Sea Link Energy Cable

Appendix D6 to the Natural England Deadline 6 Submission

Natural England's Additional Comments on Marine Physical Environment

Planning Inspectorate Reference EN020026

Plate 5.1 Offshore scheme cable crossings and areas of rock backfill

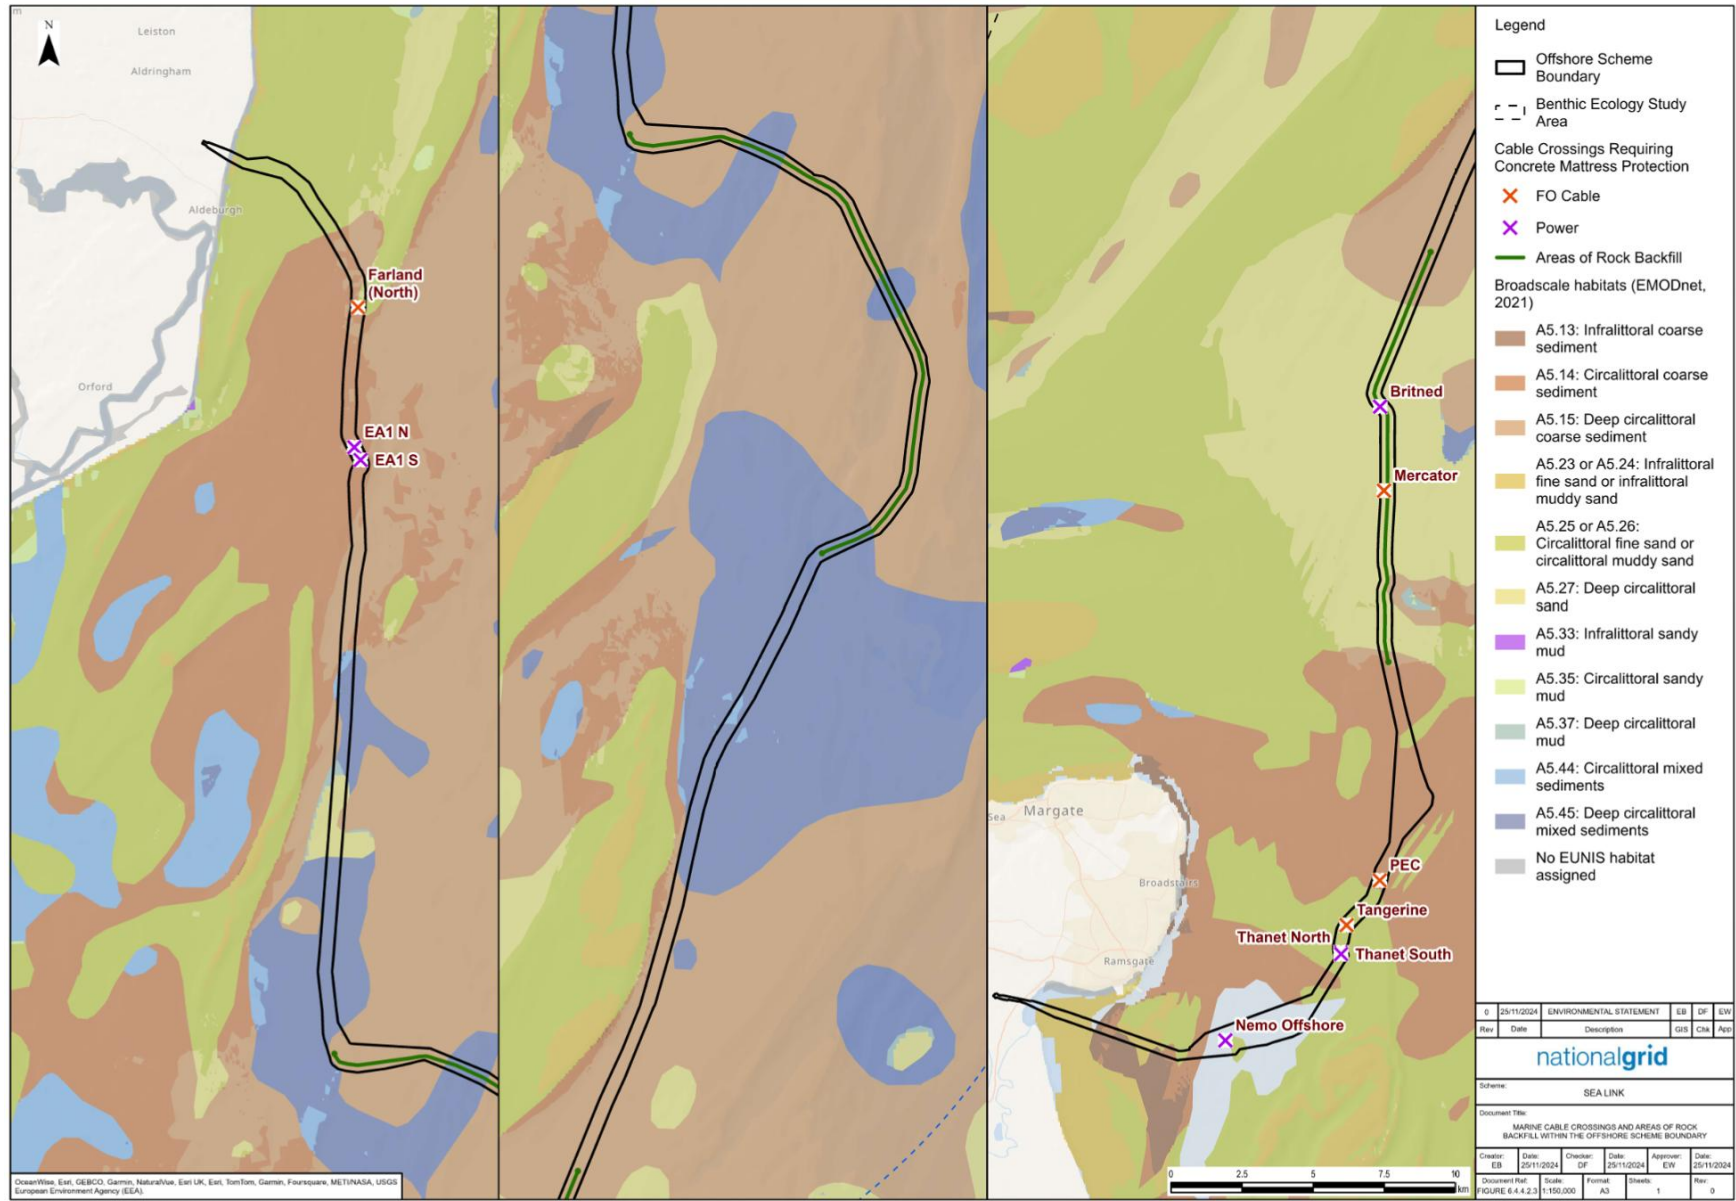
3	5.1.4	Natural England notes that the 'high risk' areas requiring rock backfill along the offshore route are identified in the CSIP as KP 38 to KP 58, and KP 81.5 to KP 96.5. However, these do not quite	We advise that clarification is needed regarding the high-risk areas requiring rock backfill should be updated, as needed, across all relevant plans/documents, including the MDS. Further		N/A

align with the offshore route rock backfill sections presented in, for example, [REP5-020] which are KP 35 to KP 58; KP 81.5 to KP 96.5. It is also unclear whether these sections of rock backfill will be continuous or not. Furthermore, in [REP5-020] rock backfill is included only for the operational phase of the Project, but this is not stated in the CSIP.	clarity is also required regarding the nature of the proposed backfill sections, if they are continuous or not, and whether the rock backfill allowance in the CSIP is for the operational phase only. This should also be clarified for the other types of external cable protection proposed in the CSIP.		
4	5.1.6	Natural England welcomes the Applicant's willingness to 'factor in' the removability of cable protection for the Proposed Project. However, it is not clear what this entails.	We advise that the Applicant should clarify what 'factor in' means with regards to removable cable protection to advise on the effectiveness of this mitigation measure.		N/A
